PLANNING AMENDMENT

THE POPLARS, HOF'S GATE, MOULTON

Re-siting of dwelling 3 metres to north,
deletion of rear covered walkway and
alterations to fence/retention at rear.

Amendment: Resiting of dwelling 3 metres to north, deletion of rear covered walkway & alterations to fenestration at rear

Drawing No. 1/933/2

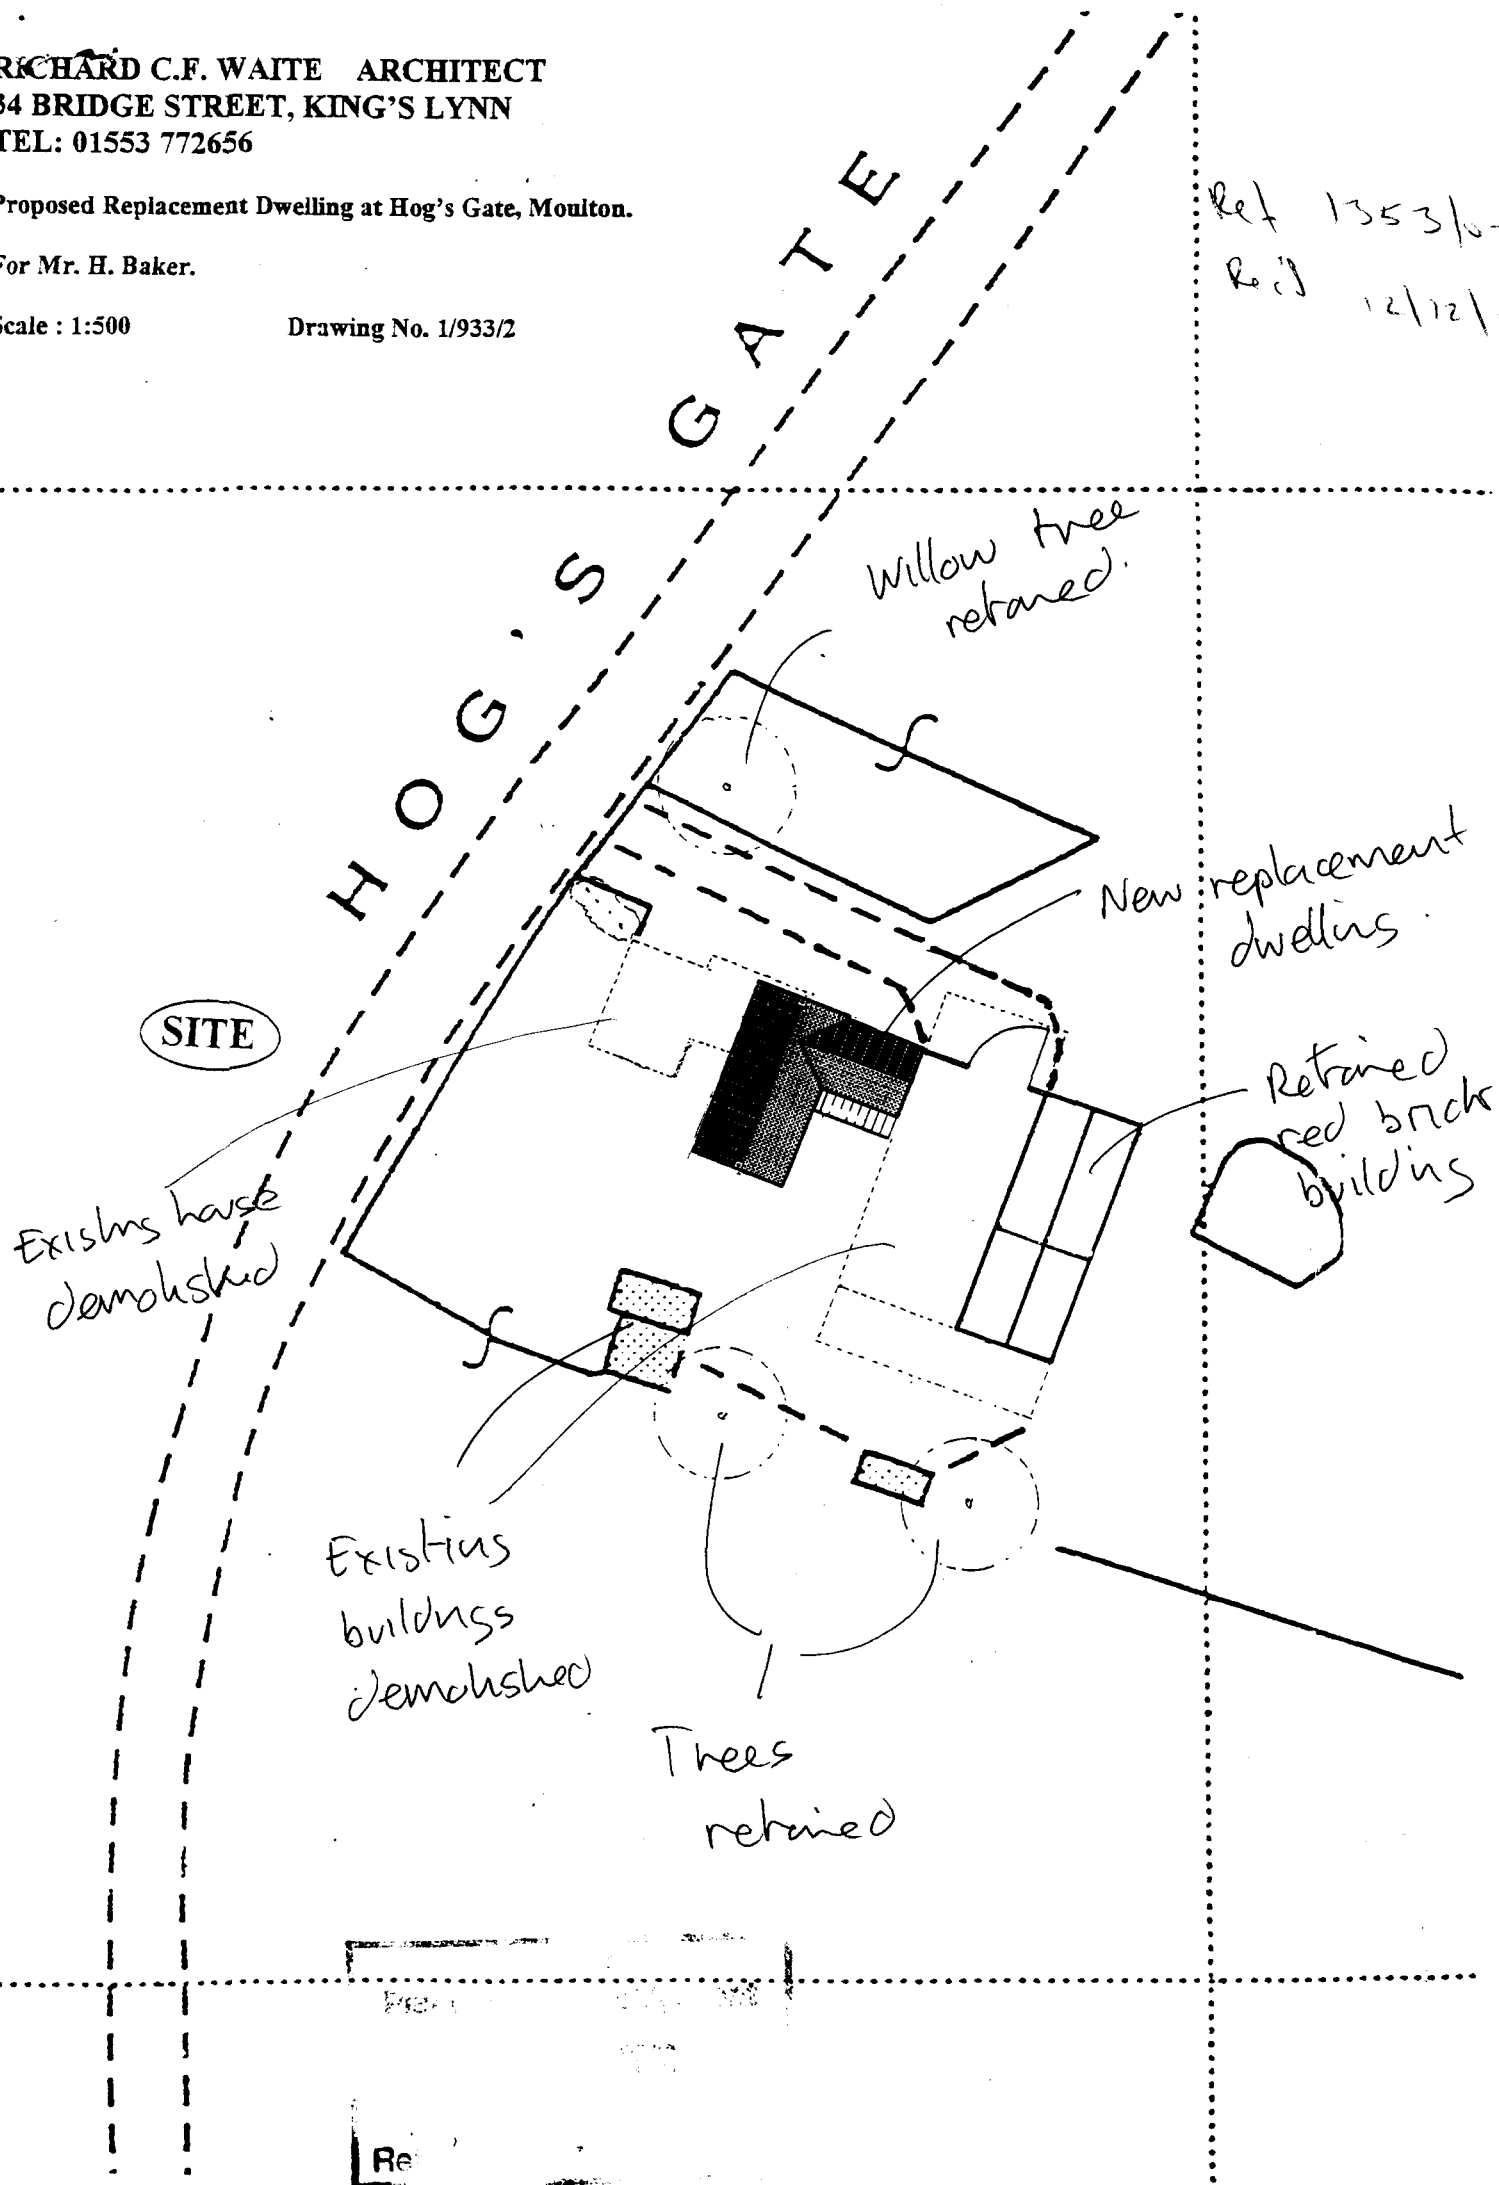
1. The rear covered walkway at ground level on the southern elevation of the rear extension will not be built.
2. The rear door to the property has been moved from the kitchen into the utility room and the gap left by the door will become a window.
3. The siting of the house will be moved approximately 3 metres to the north. This is because we have realised that once built, the view from the main bedroom will be obscured by the roof of the outbuilding.

1. As advised in our earlier letter, the house has been moved 3 metres to the north. This has restricted the space available for the drive from the public highway. We therefore propose to relocate the access to the southern edge of the property leading from Hogs Gate. Other than changes in the hedge along the front of the property and some internal fencing, all other landscaping items will remain the same (the new access will utilise the existing access road).

The amended details submitted in respect of the above proposal have now been considered and there are no objections to the amendment being implemented to the extent described above.

Existing & Proposed Plans and Elevations of Outbuilding at Moulton.

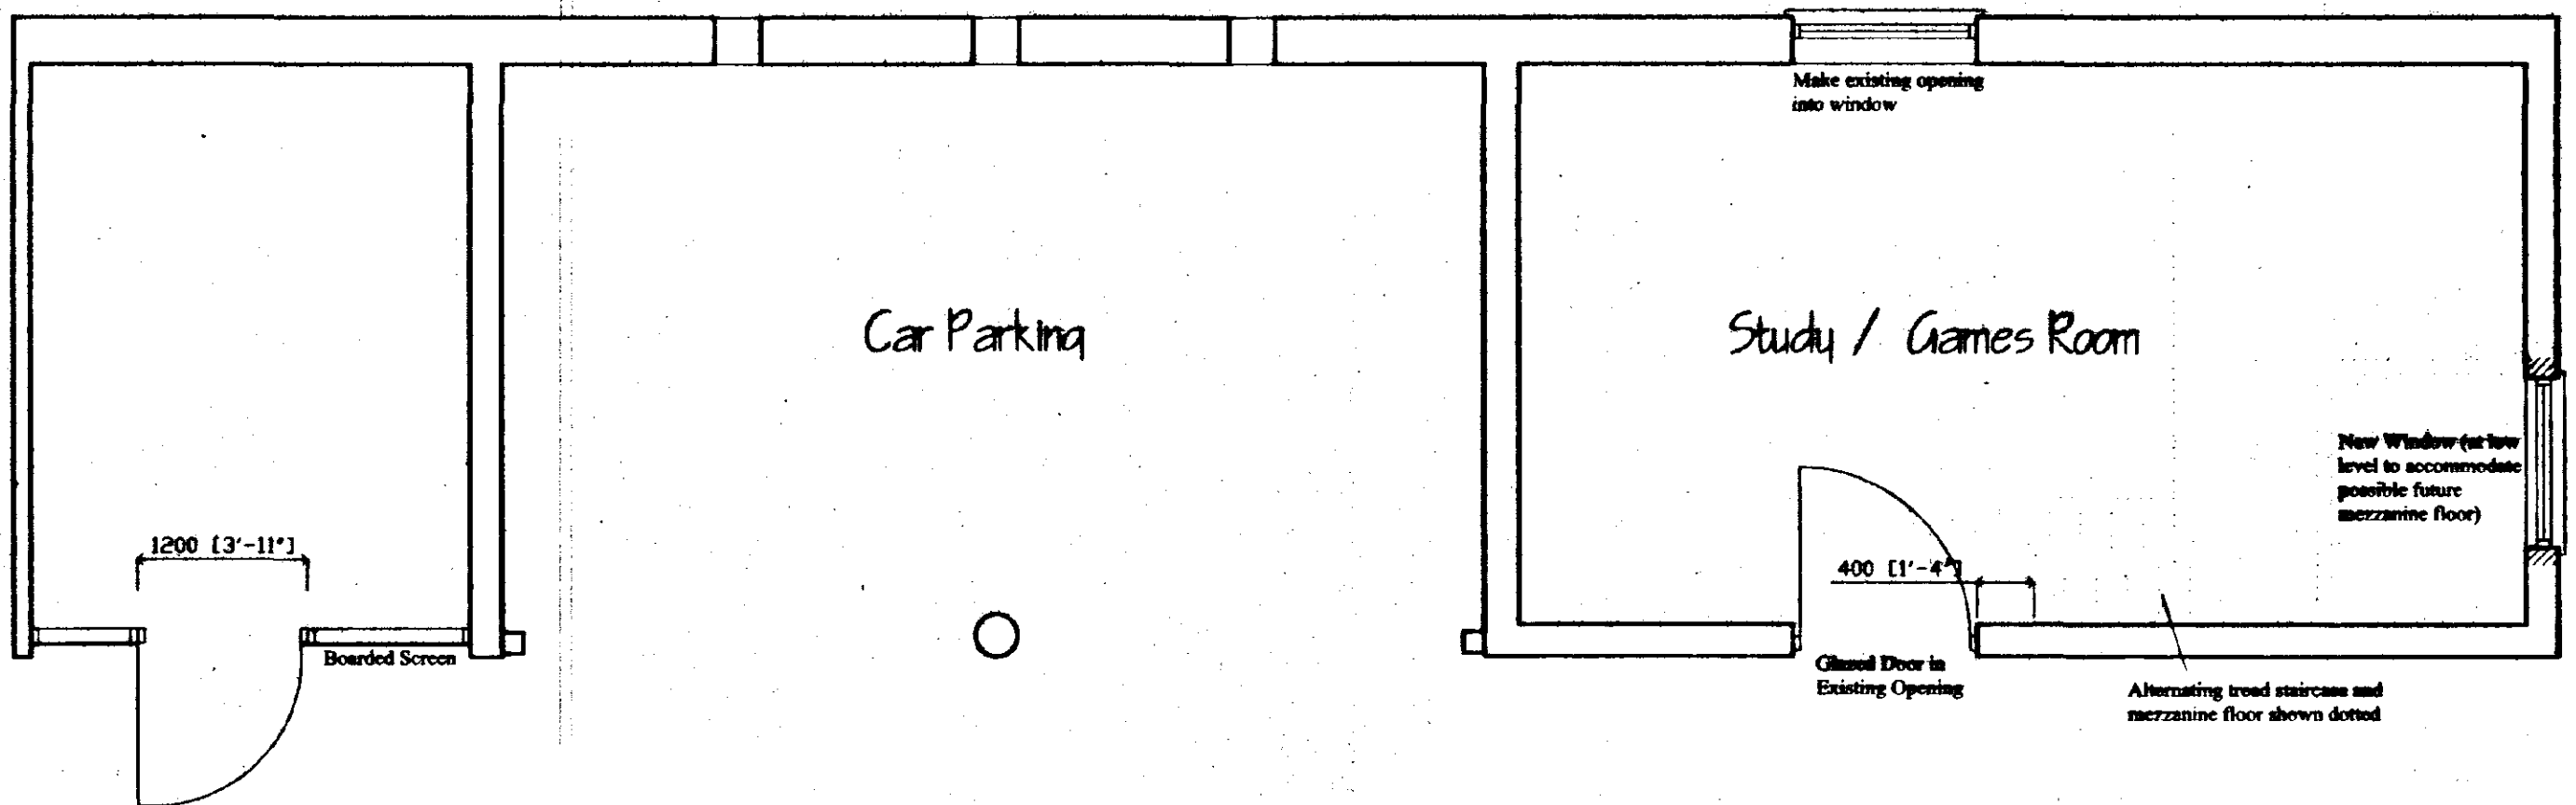
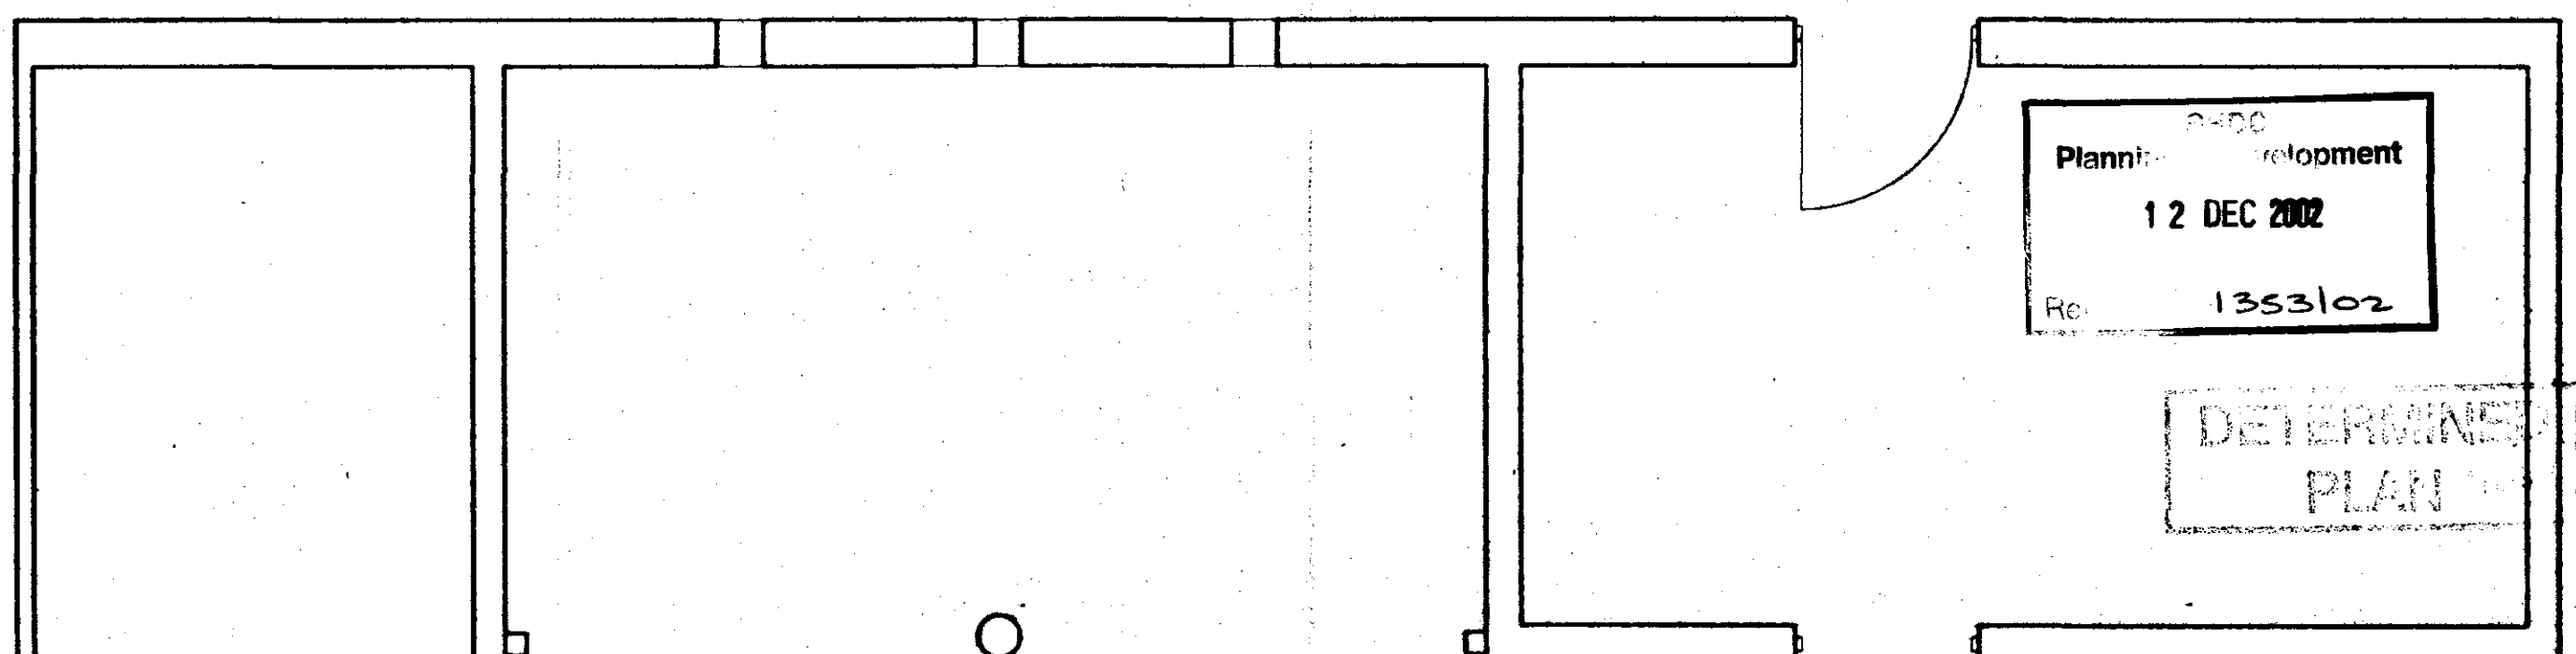
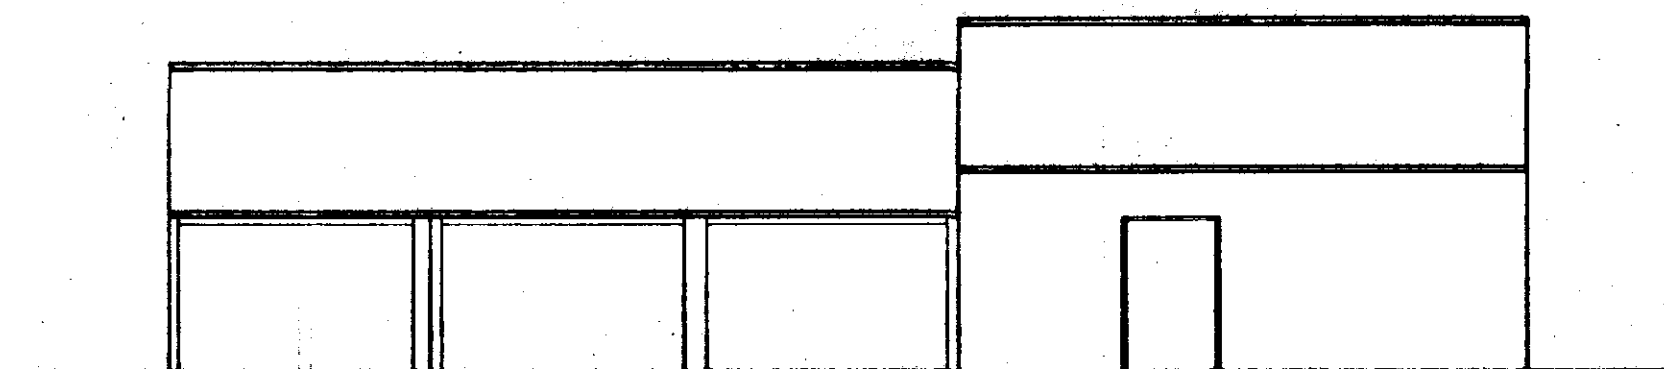
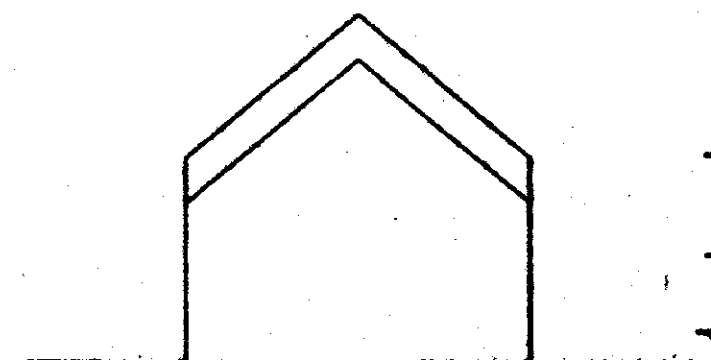
The changes relate to the outbuilding. As recently approved, we propose to take down and rebuild the right hand section of the outbuilding (as you look at it from the road). On reflection, we feel that the window in the southern gable end of the Barn will spoil the property, and would like therefore to move this window to the rear elevation looking east. I show the proposed location on the enclosed plan. In addition, we would like to position two velux windows in the roof on the rear elevation of the same building as shown on the attached plan. Without these, we feel that there would be insufficient light in the building to use it for the proposed purpose.

4. Our builders have now had a closer look at the outbuilding. They are not confident of completing successful renovation of the outbuilding on the southern end (the enclosed shed). They propose therefore to take the building down and rebuild using the existing bricks. The replacement building will replicate the original, subject only to the changes authorised in the Planning Permission.

The amended details submitted in respect of the above proposal have now been considered and there are no objections to the amendment being implemented to the extent described above.

The amended details submitted in respect of the above proposal have now been considered and there are no objections to the amendment being implemented to the extent described above.
